Your Ref: EN010137 – Mona Offshore Wind Farm

7 August 2024

SFF Response on Mona proposed offshore windfarm application Consultation

Figure 1.3: Indicative location of Scallop Mitigation Zone.

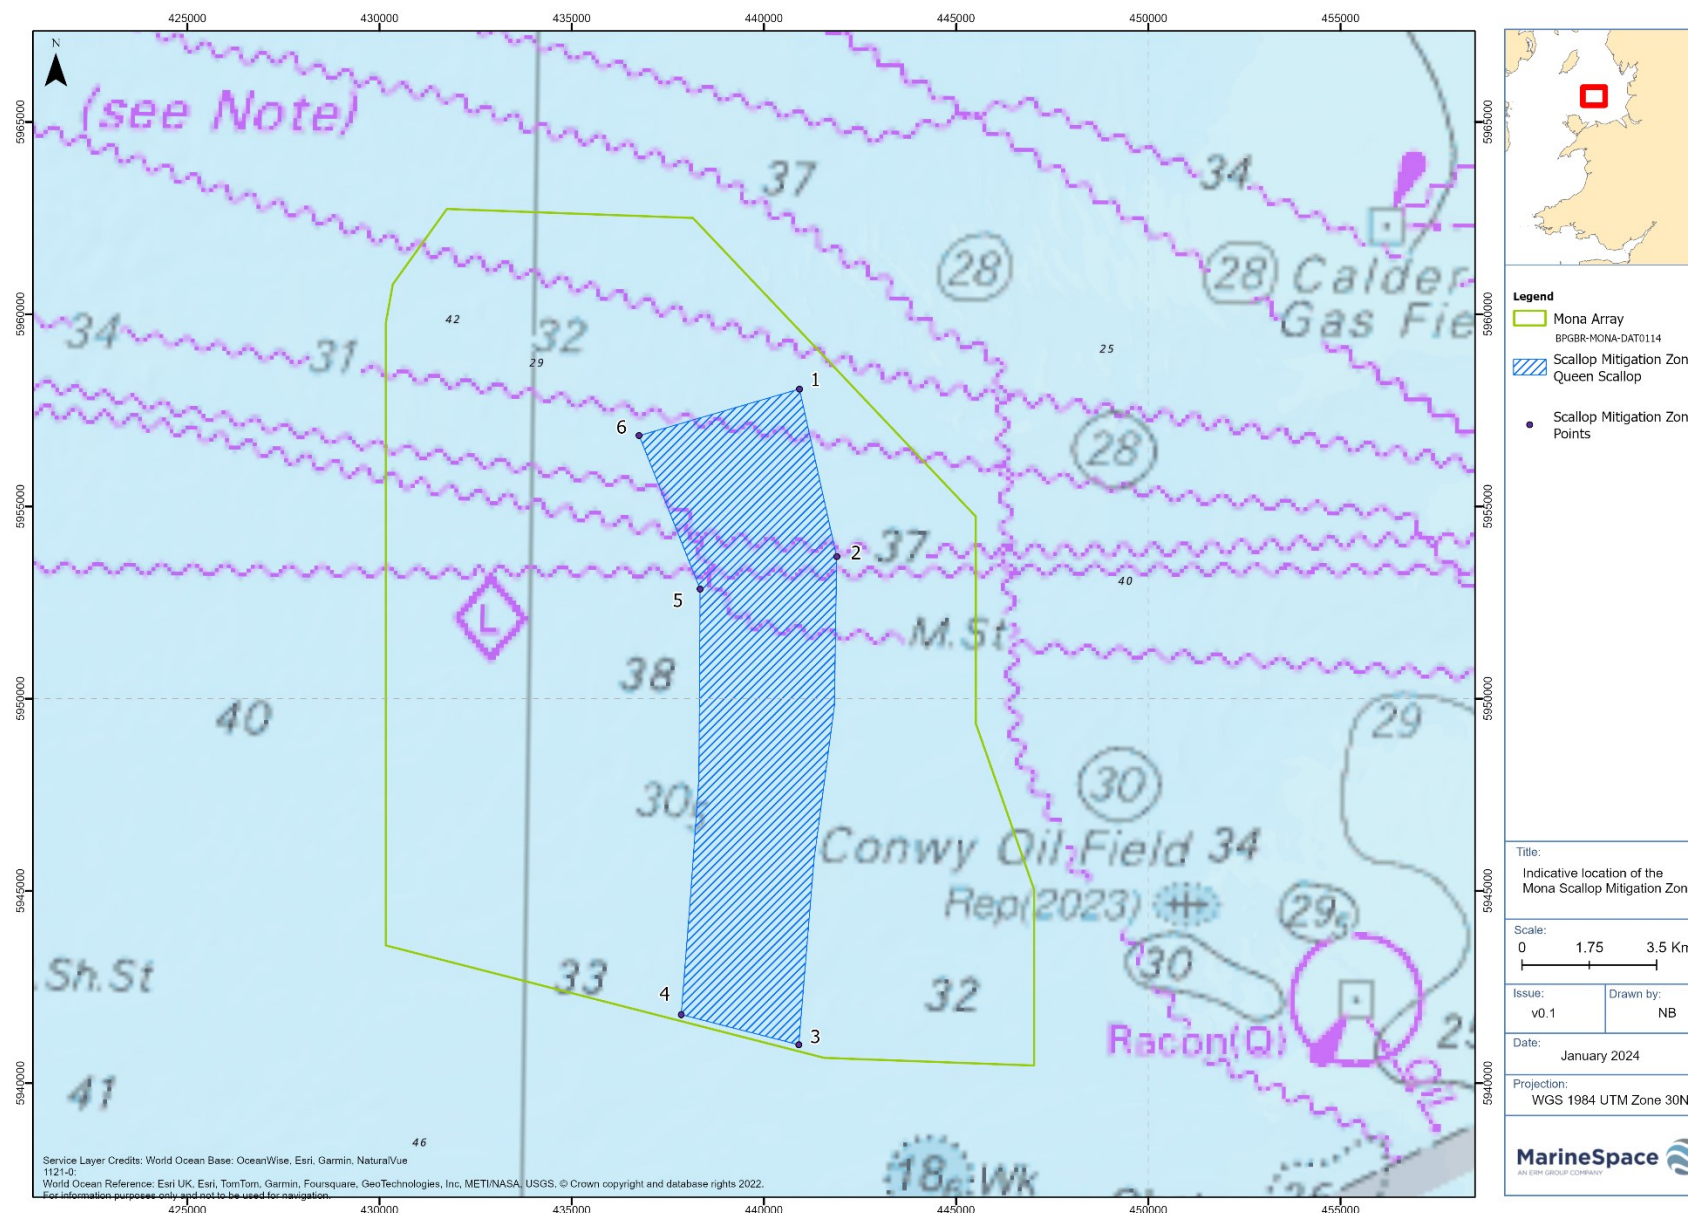
An additional concern of the FLCP is the SMZ, which, based upon the WCSP providing coordinates to the applicant, the SMZ corridor as it stands is some 3.2km in width, however, is only circa 35% of what was communicated to the applicant. It is also noted that the SMZ is indicative, the SMZ could be reduced further.

The Mona array and the export cable corridor (ECC) to the South shall be situated on circa 40% of 2023's fishing activity. In examining the SMZ detailed in the FLCP the net impact would mean that circa 30% of 2023 fishing activity for Queen Scallop fishing would fall within Mona not covered by the Scallop Mitigation Zone (SMZ).
